April 13<sup>th</sup>, 2022

Subject: 1040 Somerset Street – Temporary shoring review O/Ref. A001232 – 1040 Somerset

A EAST ELEVATION
1:100

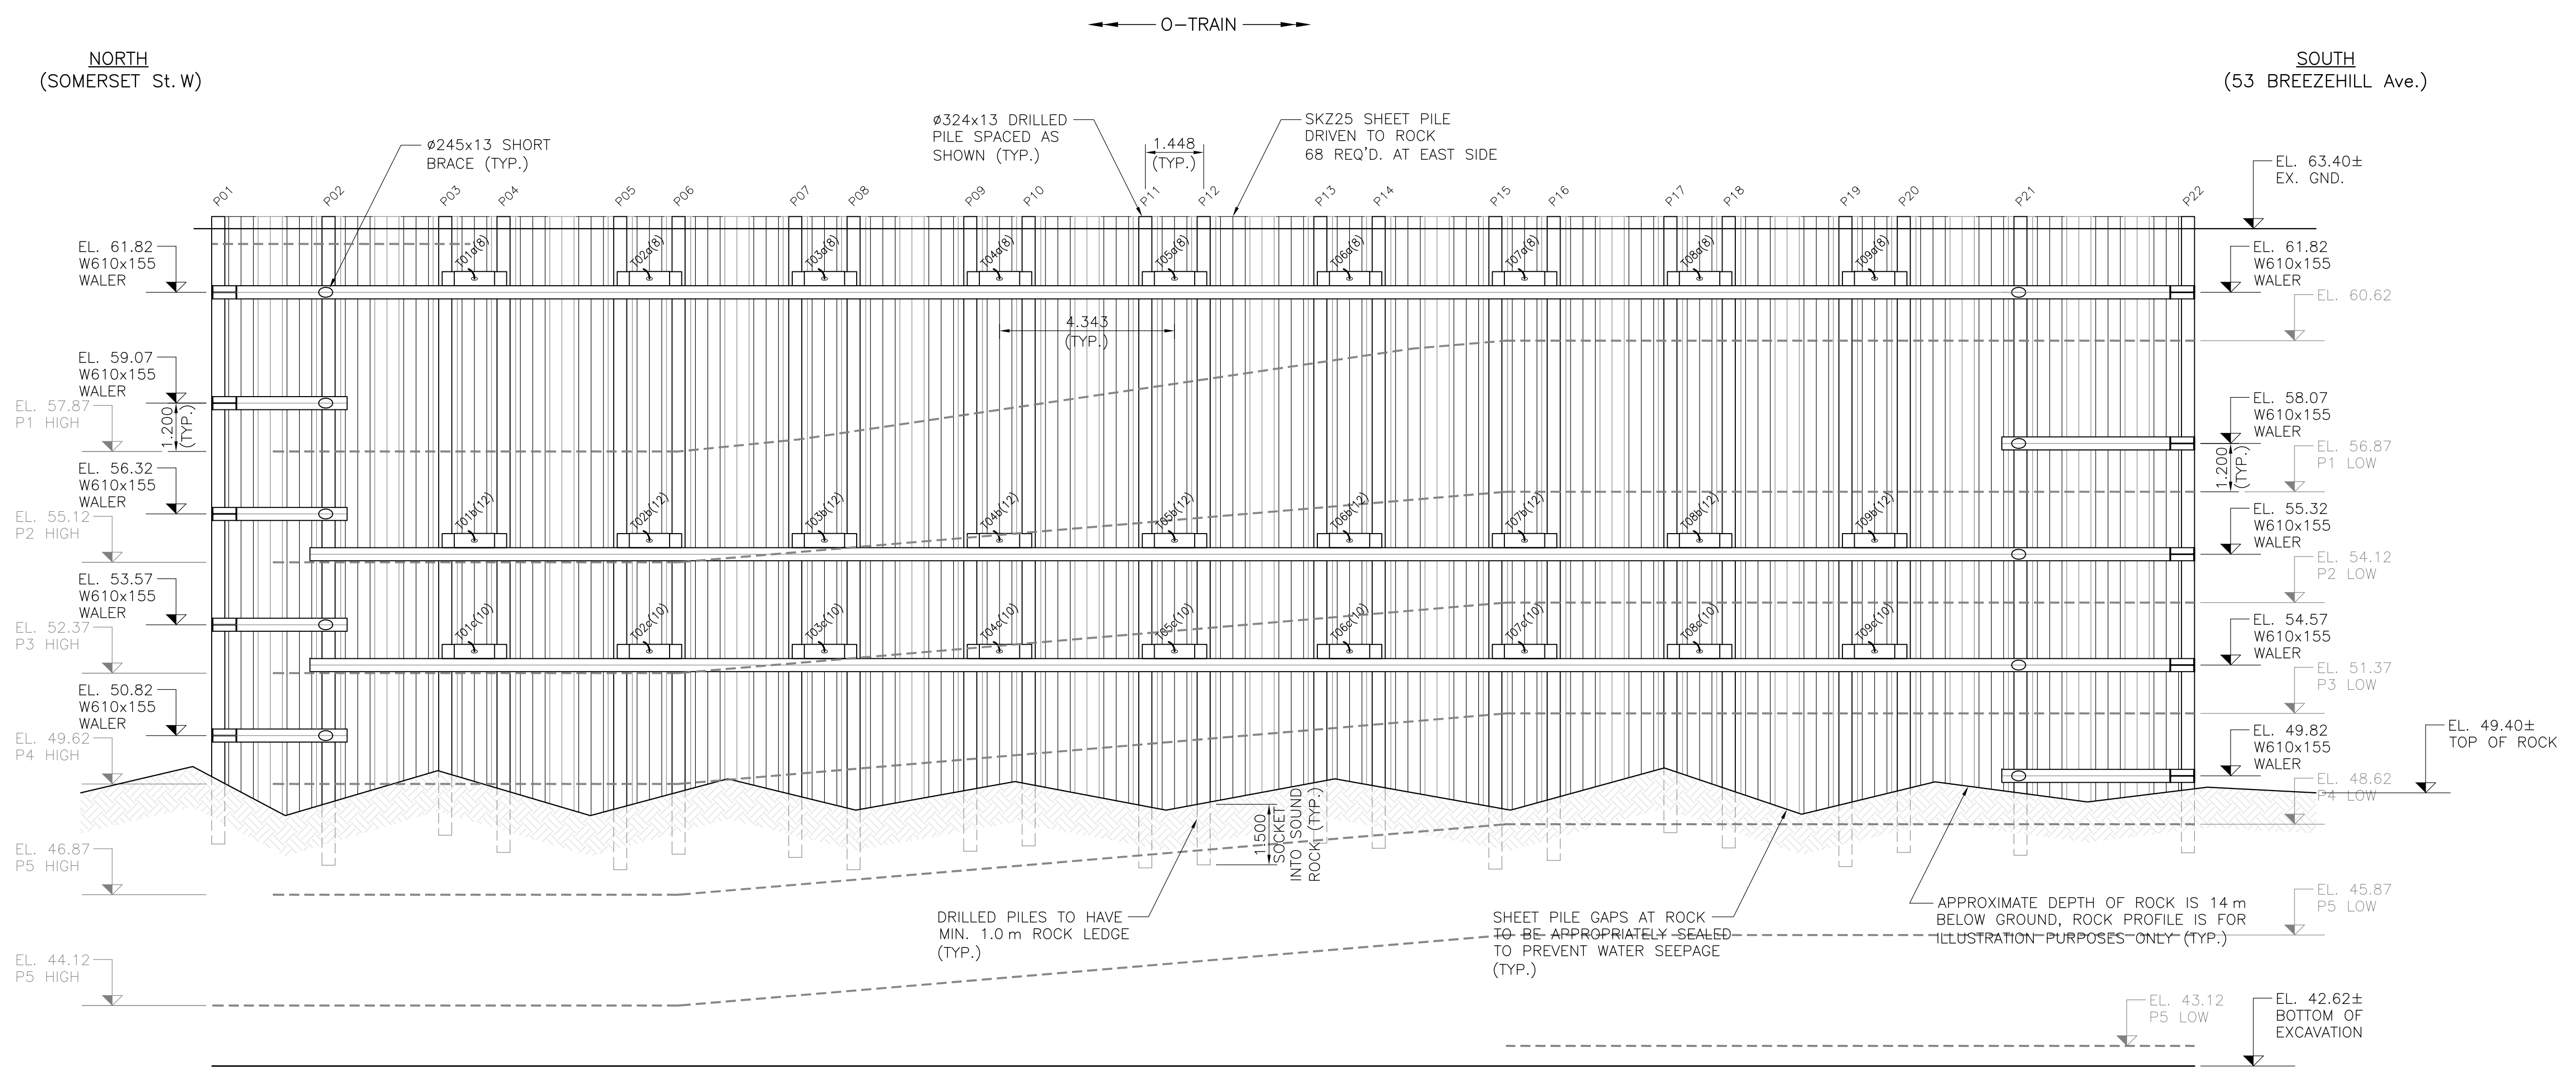
The size and spacing of the piles are adequate to support the sheet piles and tie backs. Regarding the sheet piles, the distance between the walers in the middle portion of the east and west elevation seams high but a validation was made, and the resistance and deflection meets the performance level.
